From: Sue Howell
Sent: 13 February 2019 12:38
To: Planning.Responses
Cc: Michael Eastham
Subject: RE: Planning Consultation on: AL/129/18/OUT

Comments from Greenspace

APPLICATION **AL/129/18/OUT**

Description of Works: Outline application with some matters reserved
for the development of 55 No. units with public
open space & affordable housing (resubmission
following AL/111/16/OUT).

Appendix II: proposed site

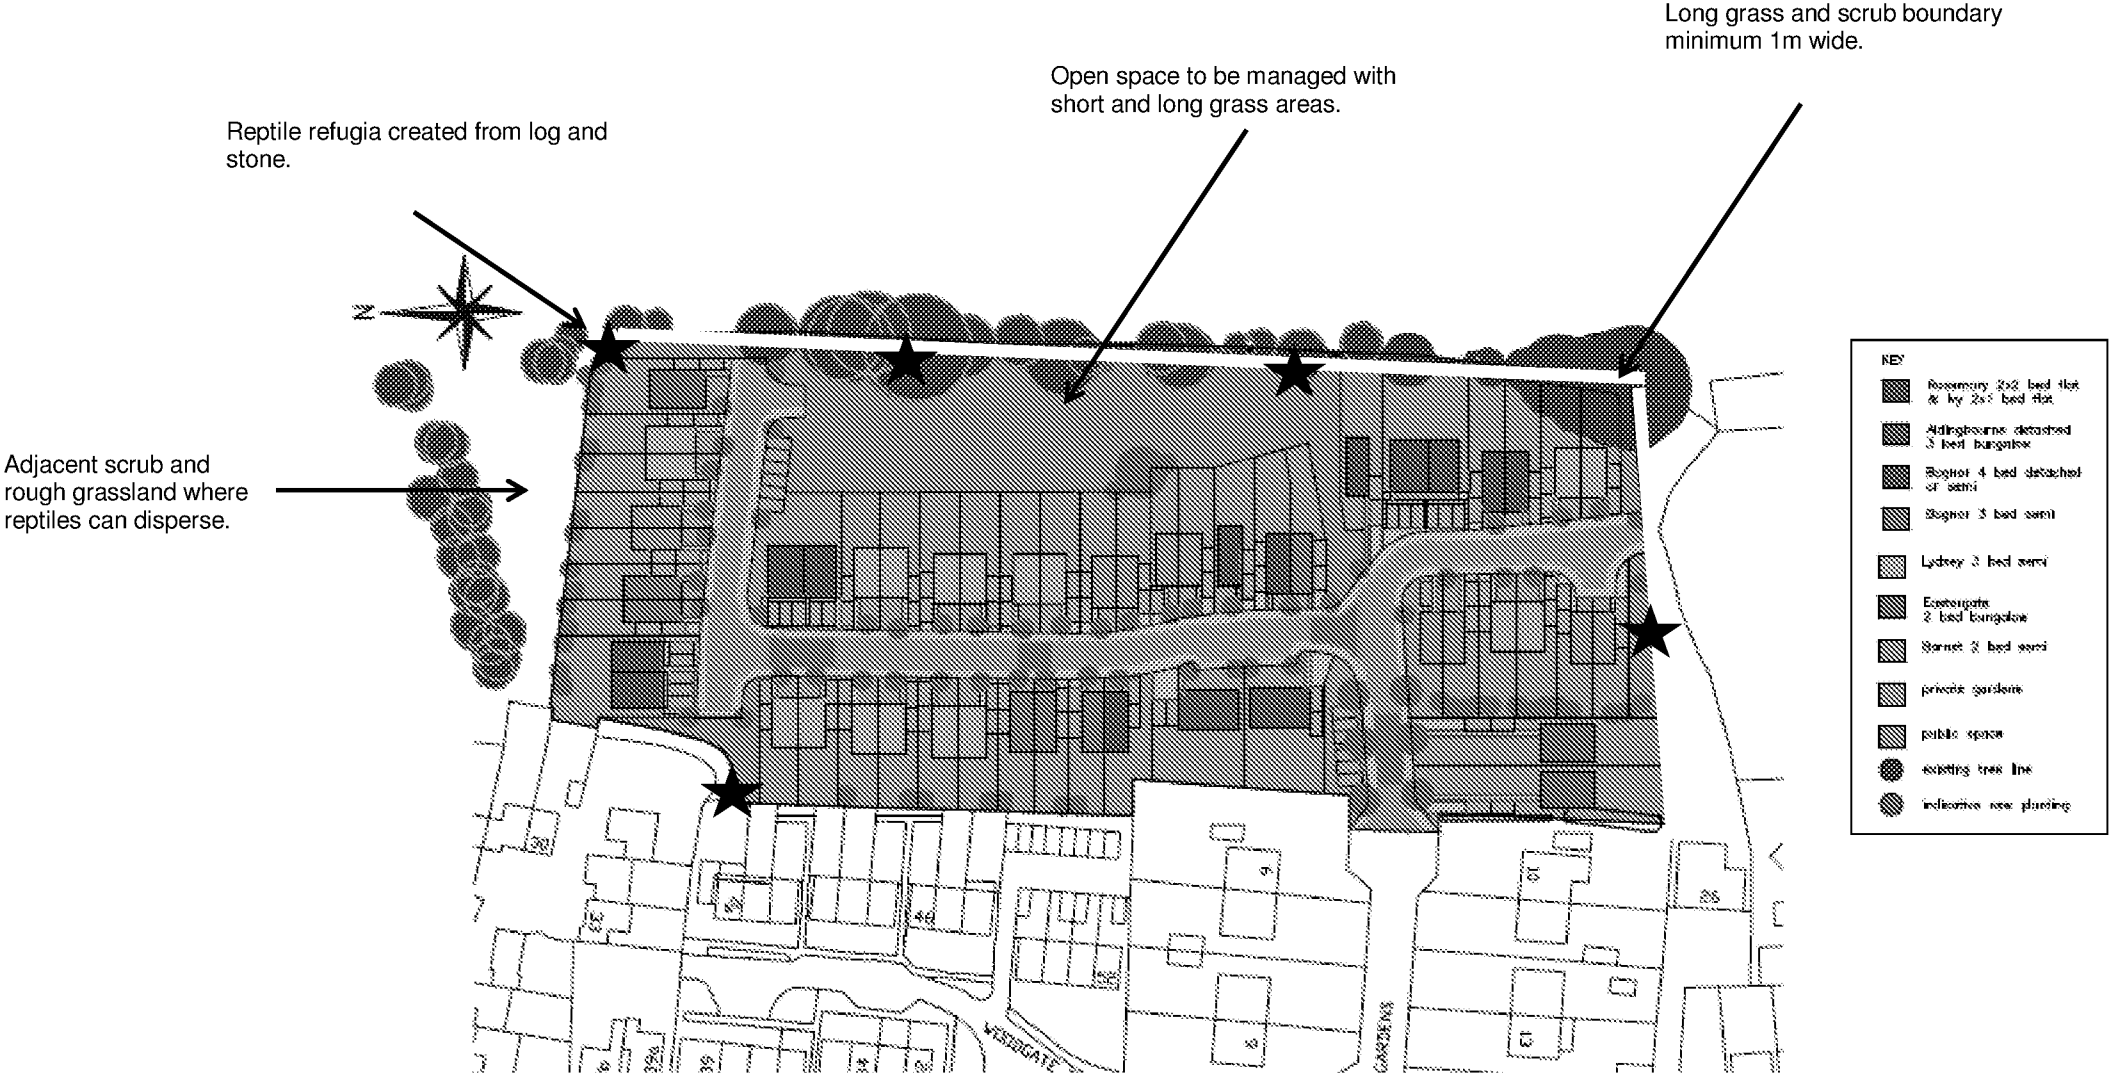
The open space indicated is still shown to the East of the development which whilst this would allow for the protection of the existing trees and TPO tree group it would provide a POS area which is hidden away behind rear gardens where a centrally situated open space area would provide an area which would be better located. Consideration should be given to the layout proposed and whether the dwellings could be facing POS rather than as presently planned.

With the number of dwellings on this proposal being up to 55no this would trigger the need for onsite LEAP, LAP Multi Use Games area (MUGA) contribution and landscaped open space areas. There is no indication of where or how this is being provided on site and therefore we would request confirmation of this. S106 monies would be sought if provision for play if this is not met on site at a rate of £1600.00/dwelling (Oct 2000 index linked figure) to be allocated to local offsite play enhancement.

A tree survey relating to existing trees has been undertaken. Tree protection fencing requirements have been identified including for the TPO Group 1 TPO/AL/2/16 shown. These significant existing trees along the eastern boundary edge identified for retention, must be protected during the works as they have been identified to provide good visual amenity in addition to their biodiversity importance. These trees have the potential for a long life expectancy, with potential to become a prominent feature within the landscape and are worthy of protection, with adequate fencing according to the BS5837 (2012) Provision for fencing according to each of the trees' correct and calculated root protection area must be erected prior to the commencement of any development activities.
